Kirklees Council

Application Reference: 2024/92220

**Proposal: Erection of single storey extension to existing changing rooms and
associated alterations.**

Site: CLECKHEATON SPORTS CLUB, THE PAVILION BRADFORD ROAD BD19 3UD

Title	Site Plan
-------	-----------

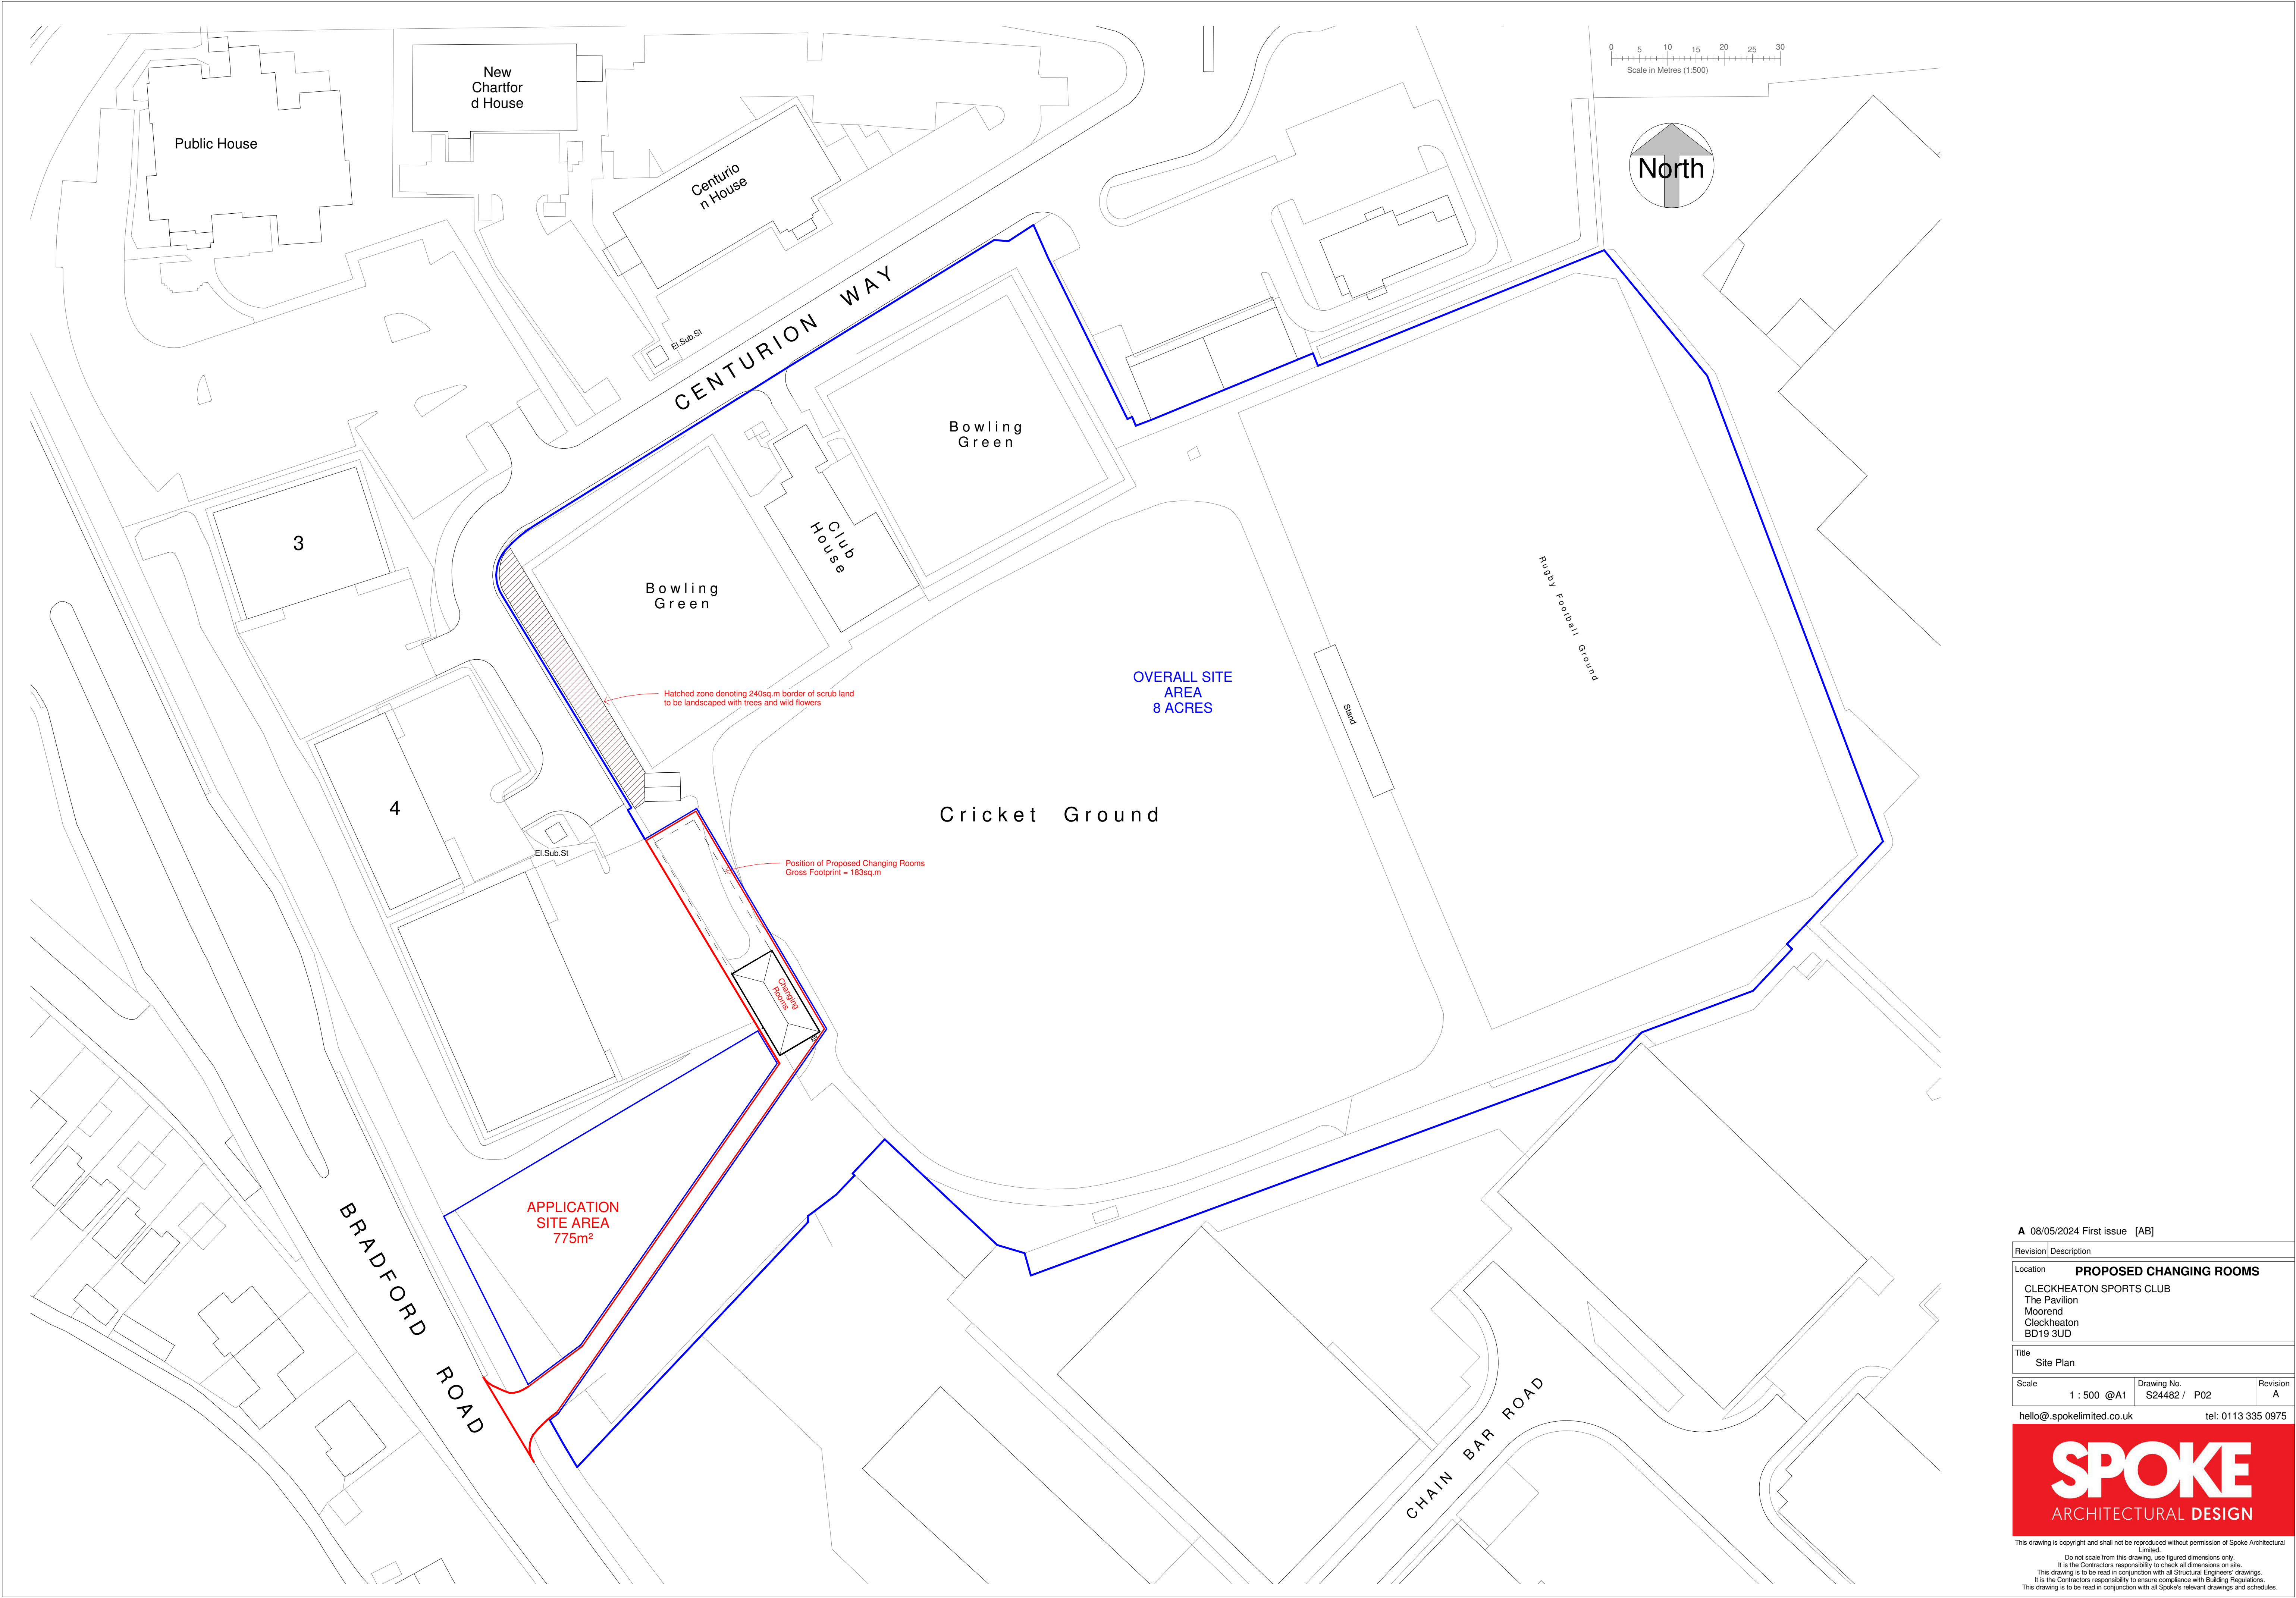
The proposal also includes an area of landscaping. This will occupy a narrow strip of land between the bowling green and the road. This area of land is incapable of accommodating a pitch and part of a pitch and therefore is considered to accord with policy exception E3 of Sport England's Playing Fields Policy in that:
